DEVELOPMENT REVIEW BOARD
TRANSPORTATION DEVELOPMENT

DRB Project Number: 1011603
Raynolds Addition

SUBJECT: Sketch Plat

LOT 4A, BLOCK 12  
RAYNOLDS ADDITION

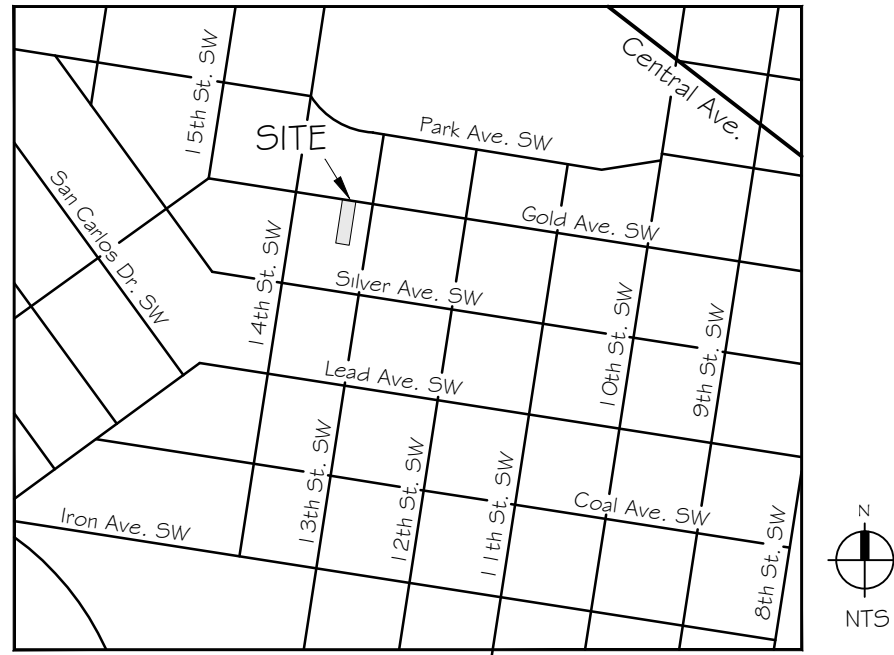
- Must add a signature line for Code Enforcement
- No adverse comment to the replat

LOT 4A, BLOCK 12
RAYNOLDS ADDITION

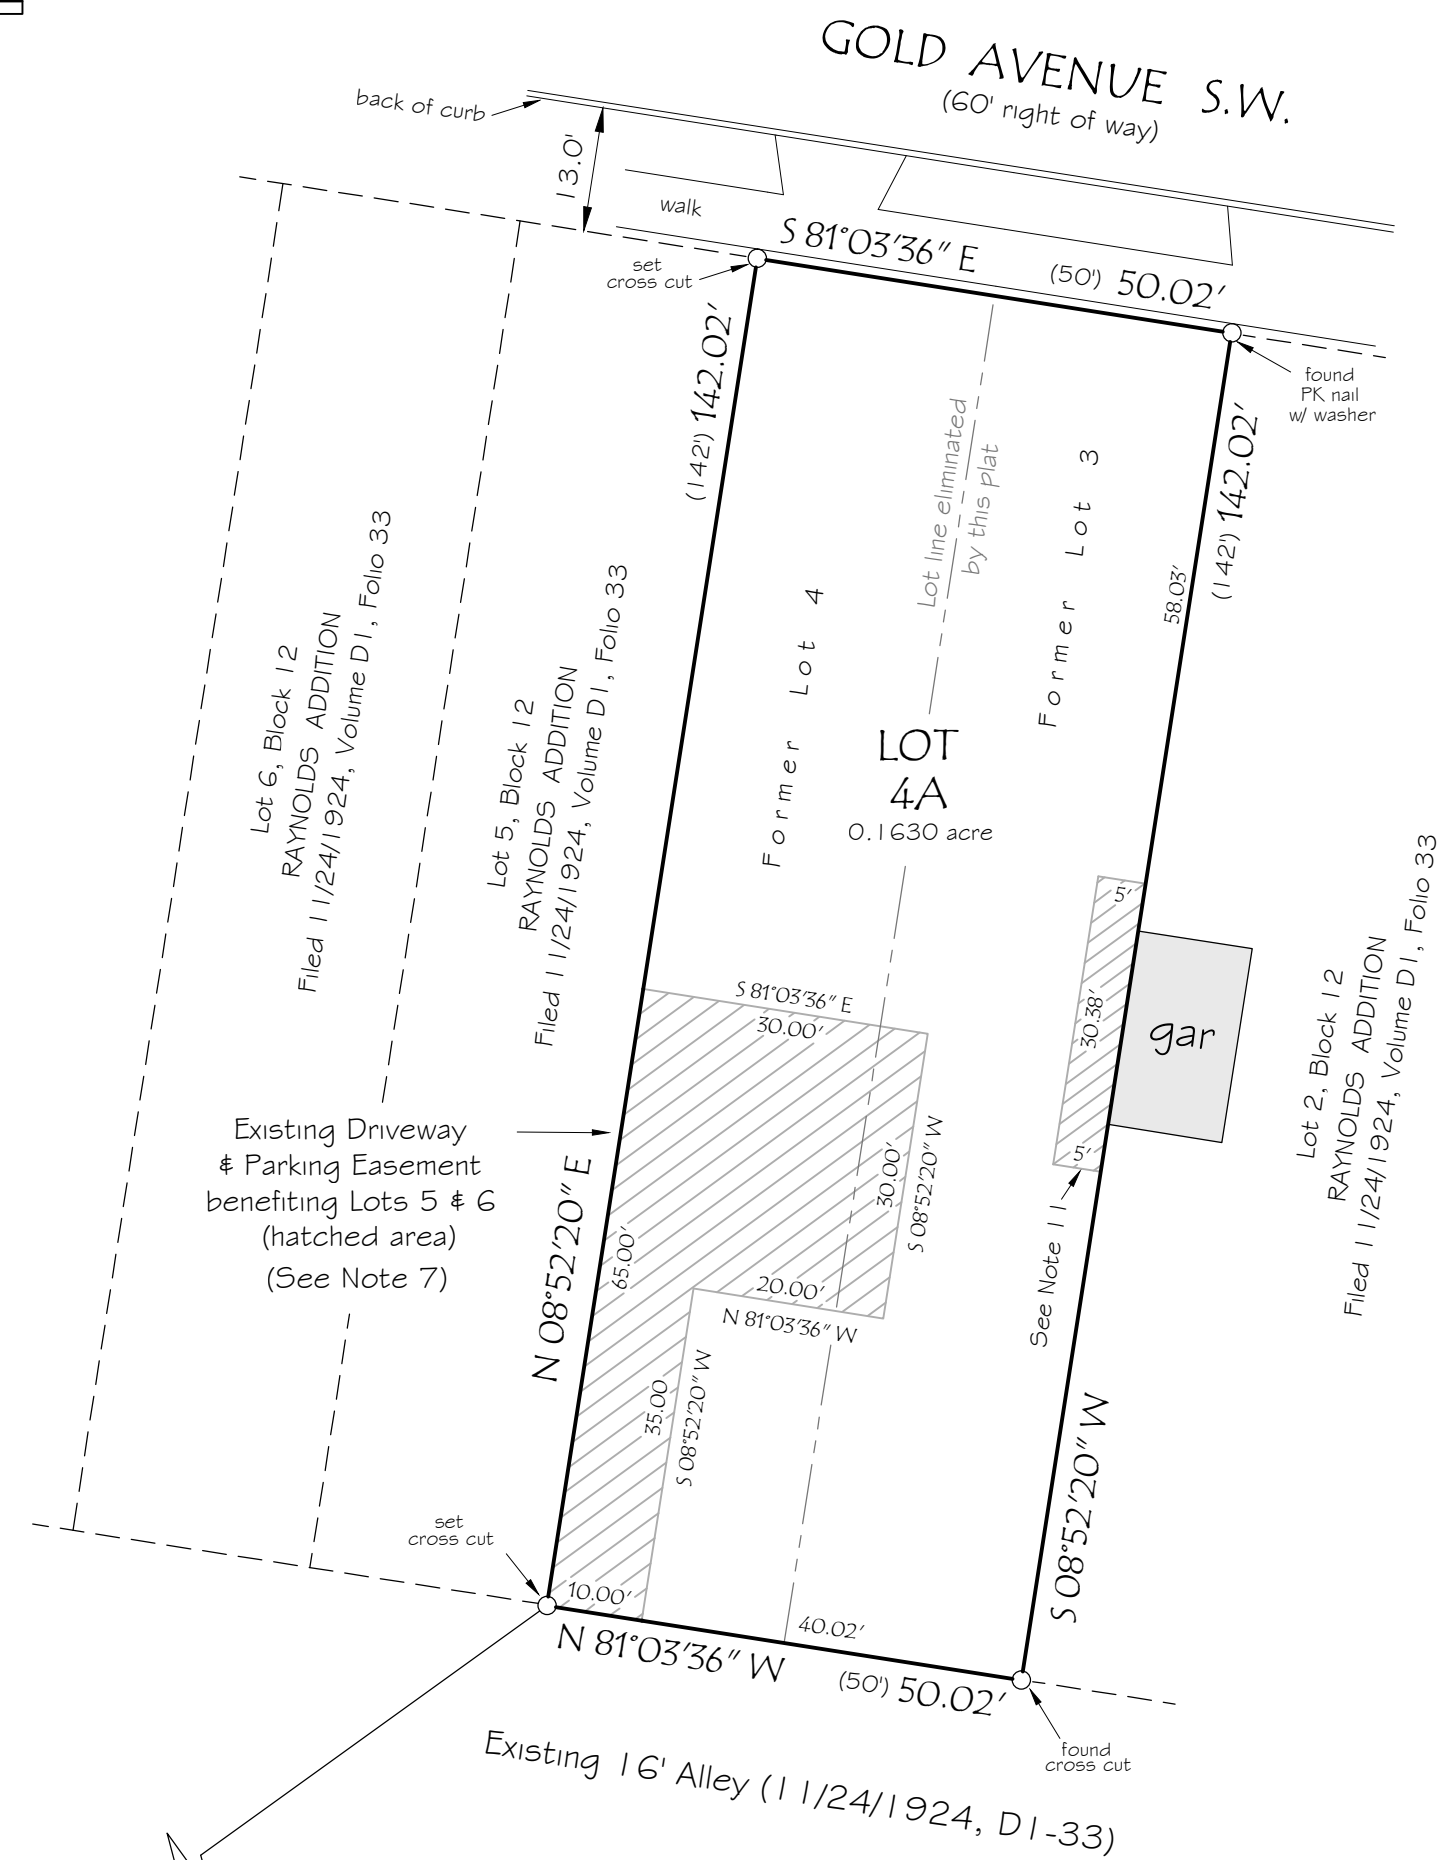
1. The driveway on the east of the site needs to be shown on the site sketch. It looks like it may be shared by the two lots so an access easement may be required. Please verify the location of the driveways.
